Rezoning Transportation Analysis

Petition Number: 2021-168

Revision Log:

Date	Description
11-19-2021	First Review (KP)
12-20-2021	Second Review (KP)
03-21-2022	Third Review (KP)

RZ1.0

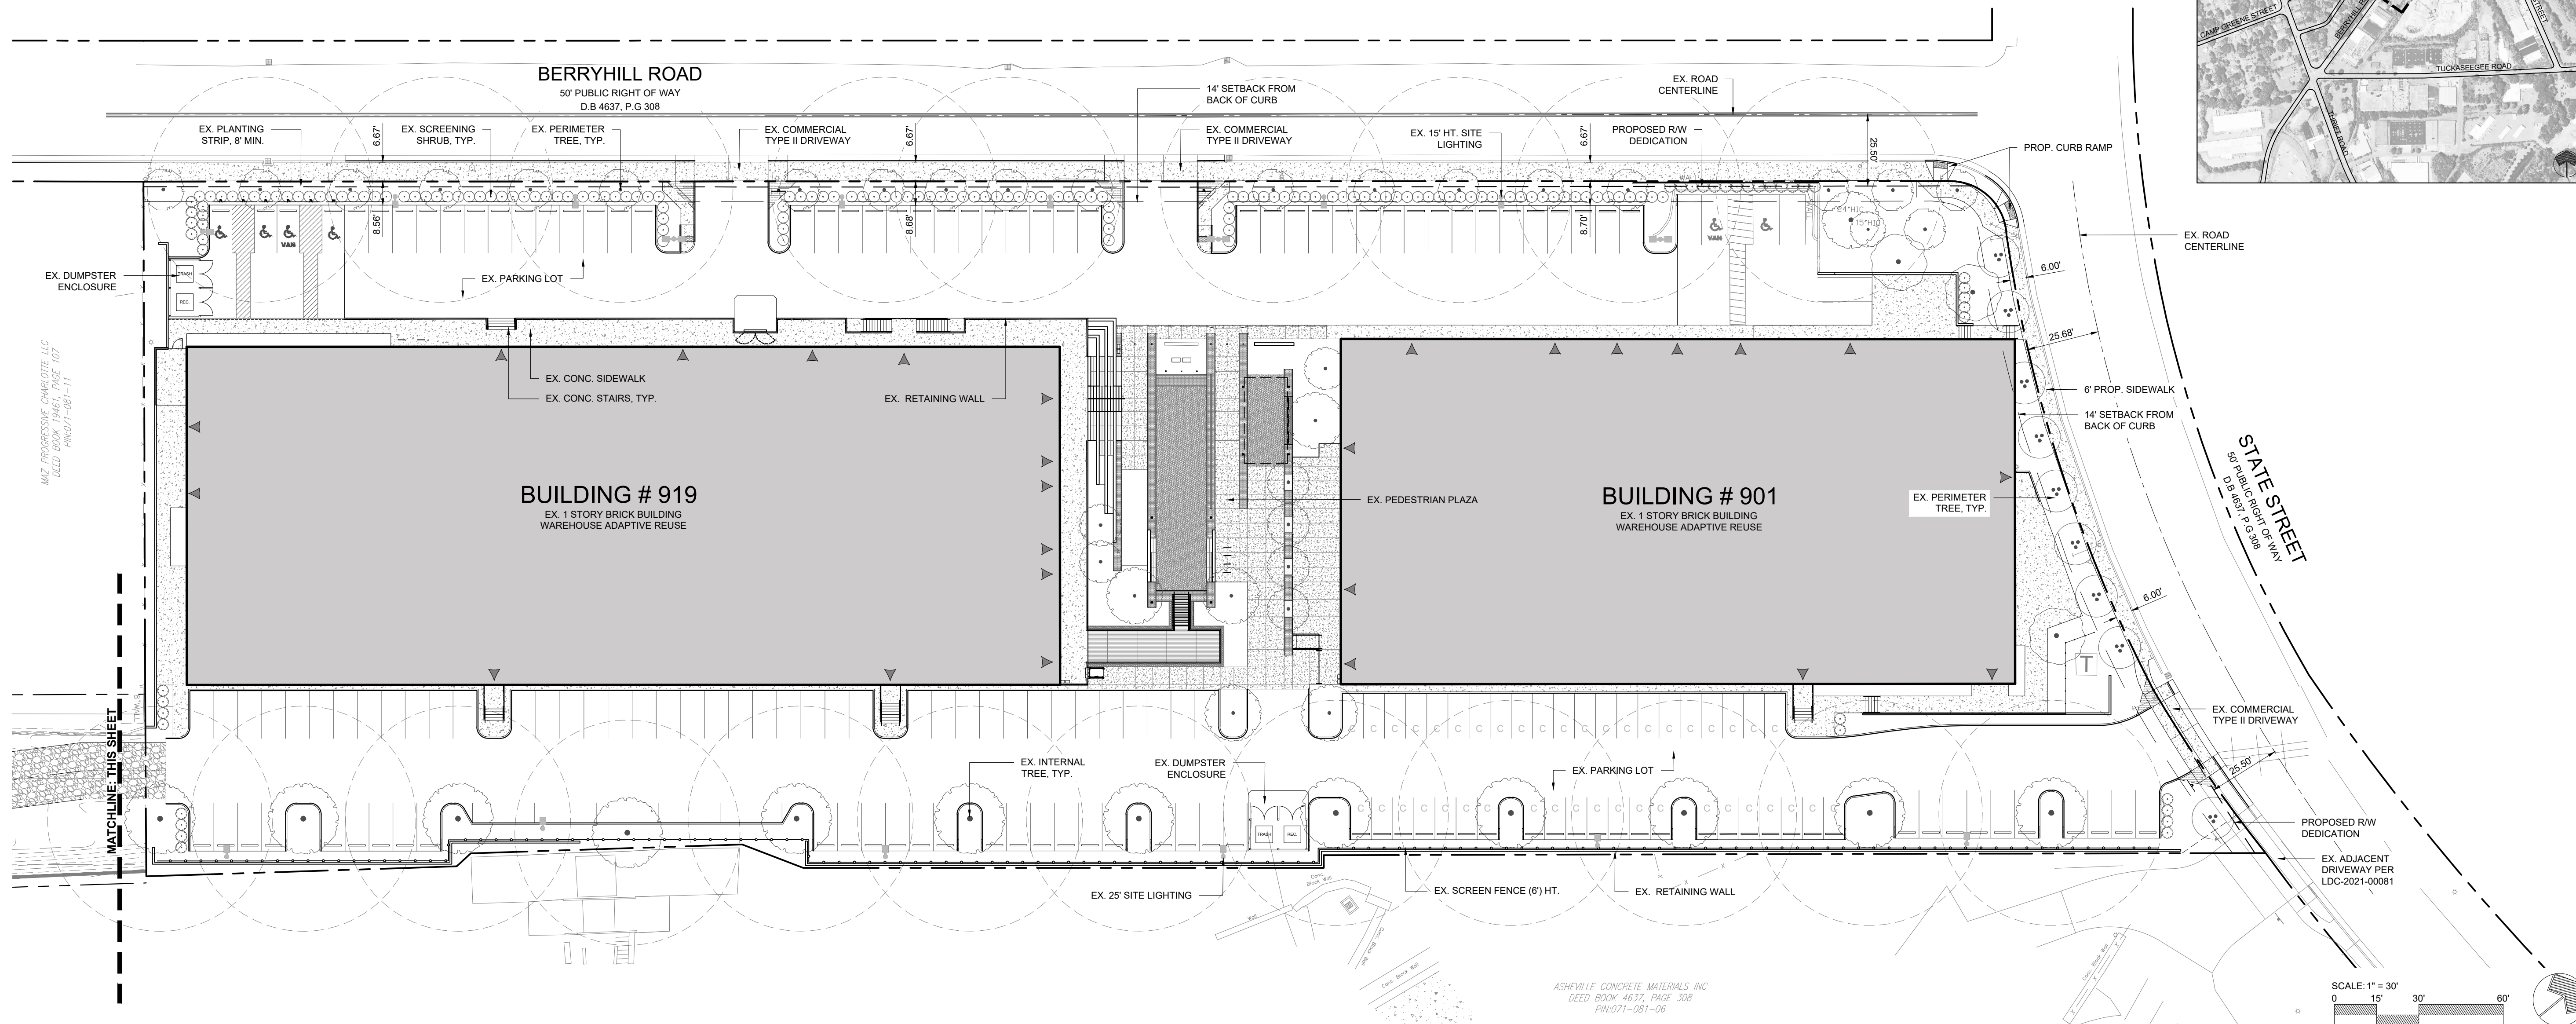
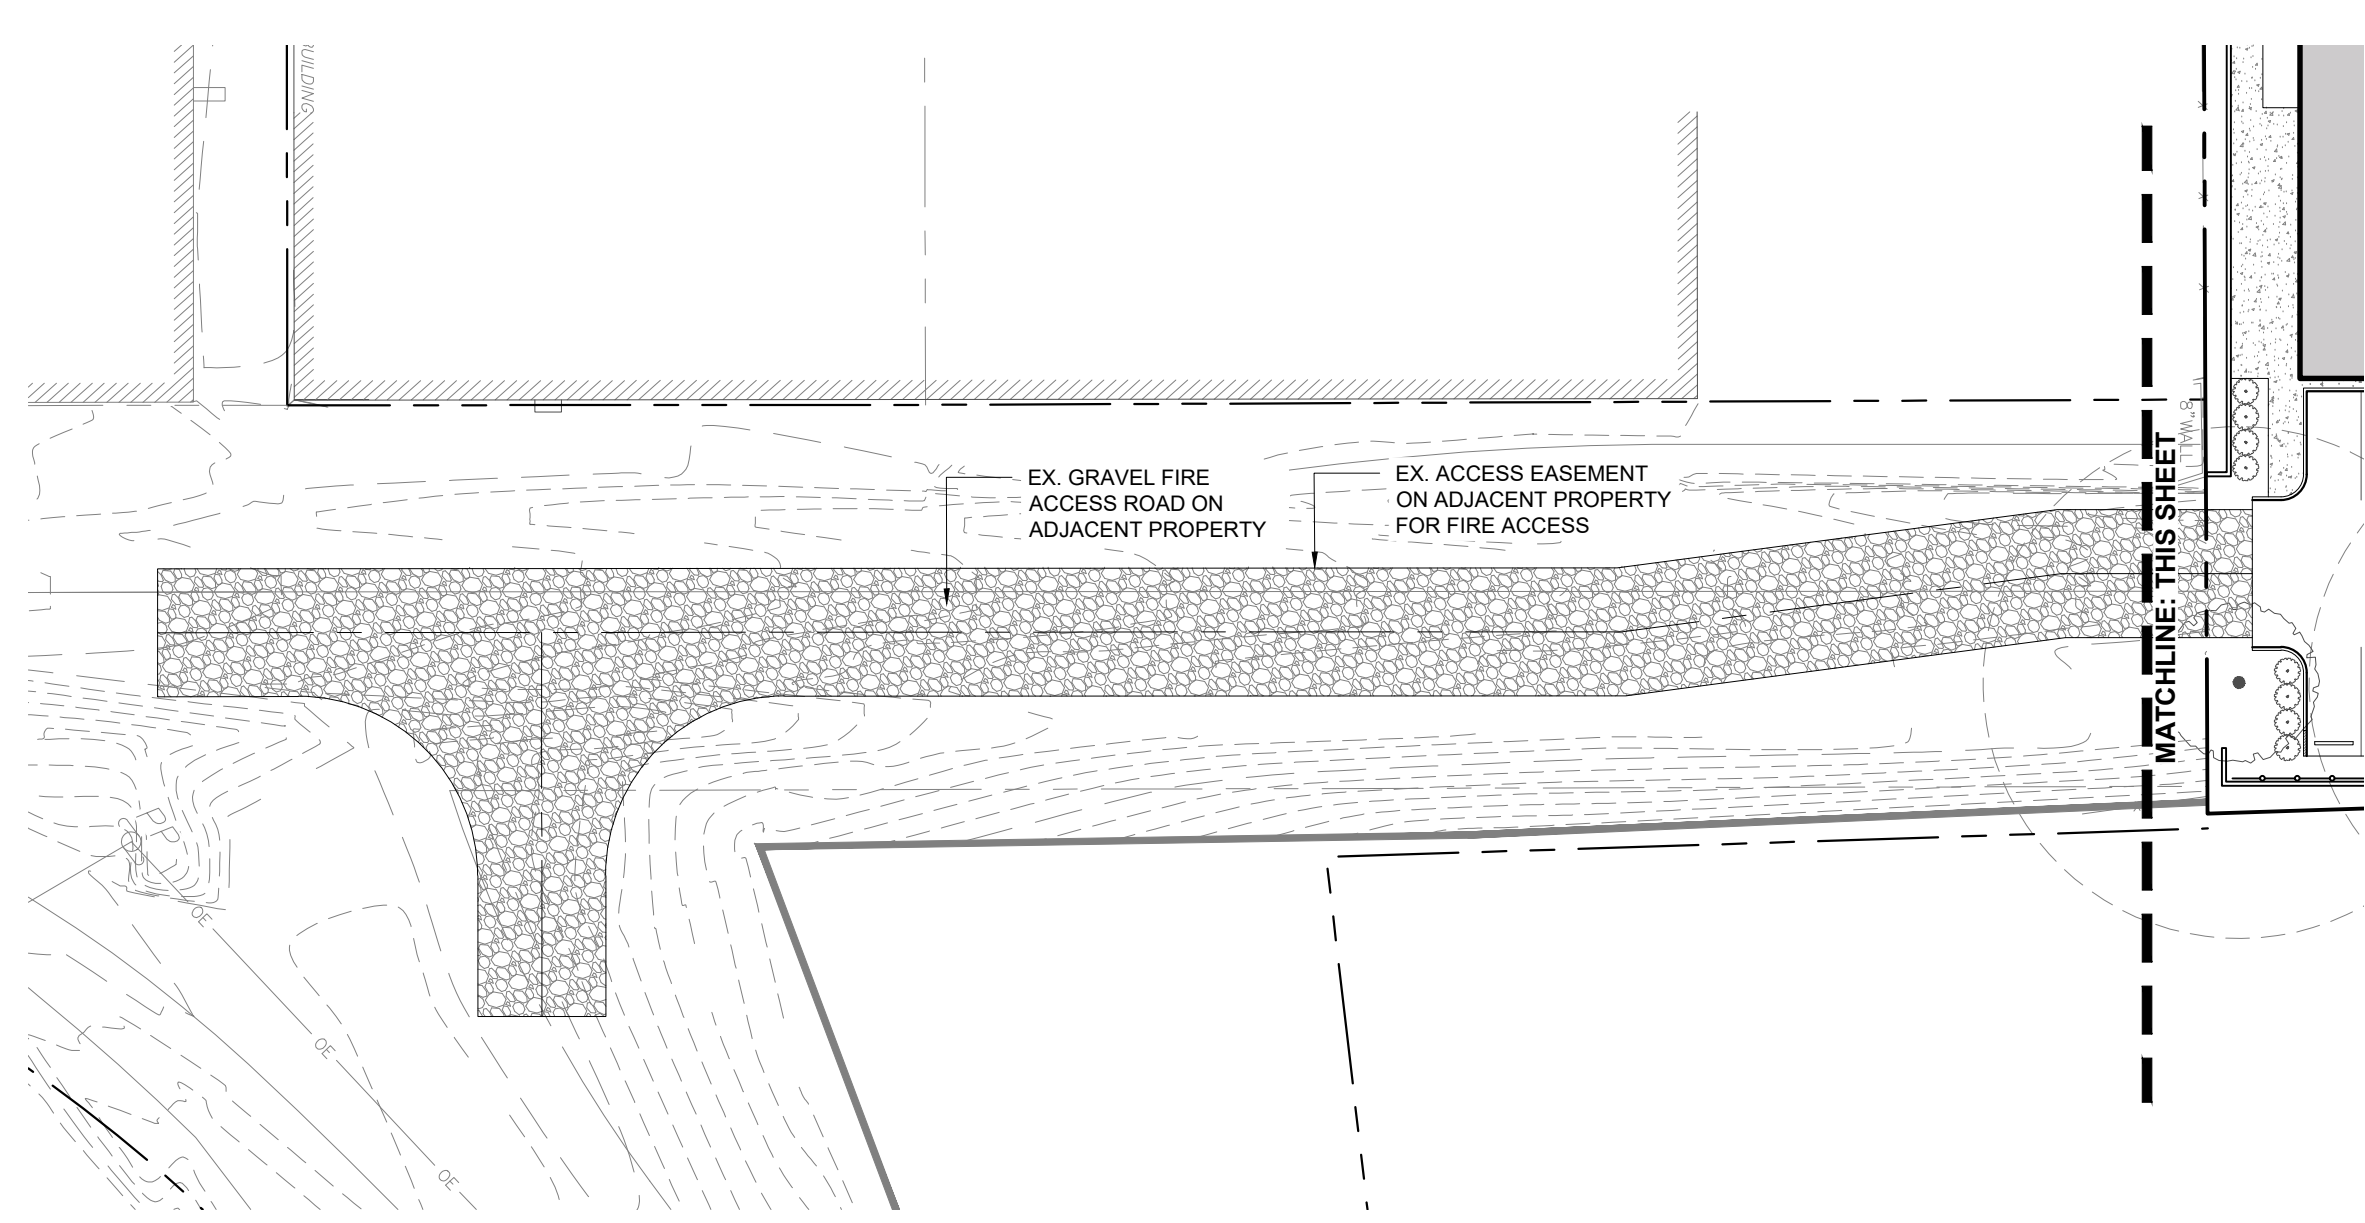
a. ~~**Berryhill Road:** Revise the site plan and conditional notes to commit to dedicated 36 feet of right-of-way from the existing road centerline, in accordance with CLDSM U-07 (Local Collector Street).~~

b. ~~**State Street:** Revise the site plan and conditional notes to commit to dedicated 36 feet of right-of-way from the existing road centerline, in accordance with CLDSM U-07 (Local Collector Street).~~

~~The site plan shall label and dimension the dedicated right-of-way from the existing centerline of each road.~~

4. ~~Revise site plan and conditional note(s) to commit to construct an 8-foot planting strip, and 6-foot sidewalk along the site's frontage of Berryhill Road and State Street. The planting strip and sidewalk~~

shall be oriented where the planting strip is located in between the sidewalk and back of curb. The site plan shall label and dimension both items from the back of curb and gutter.

~~**Comment Resolved as a result of 12-08-2021 Coordination Call with Petitioner:** 25.5 feet of right-of-way dedication to be provided.~~

~~Comment Resolved as a result of 12-08-2021 Coordination Call with Petitioner~~ Streetscape was previously approved due to site constraints.

~~Comment Resolved as a result of 12-08-2021 Coordination Call with Petitioner:~~ Sidewalk will be maximized as much as possible..
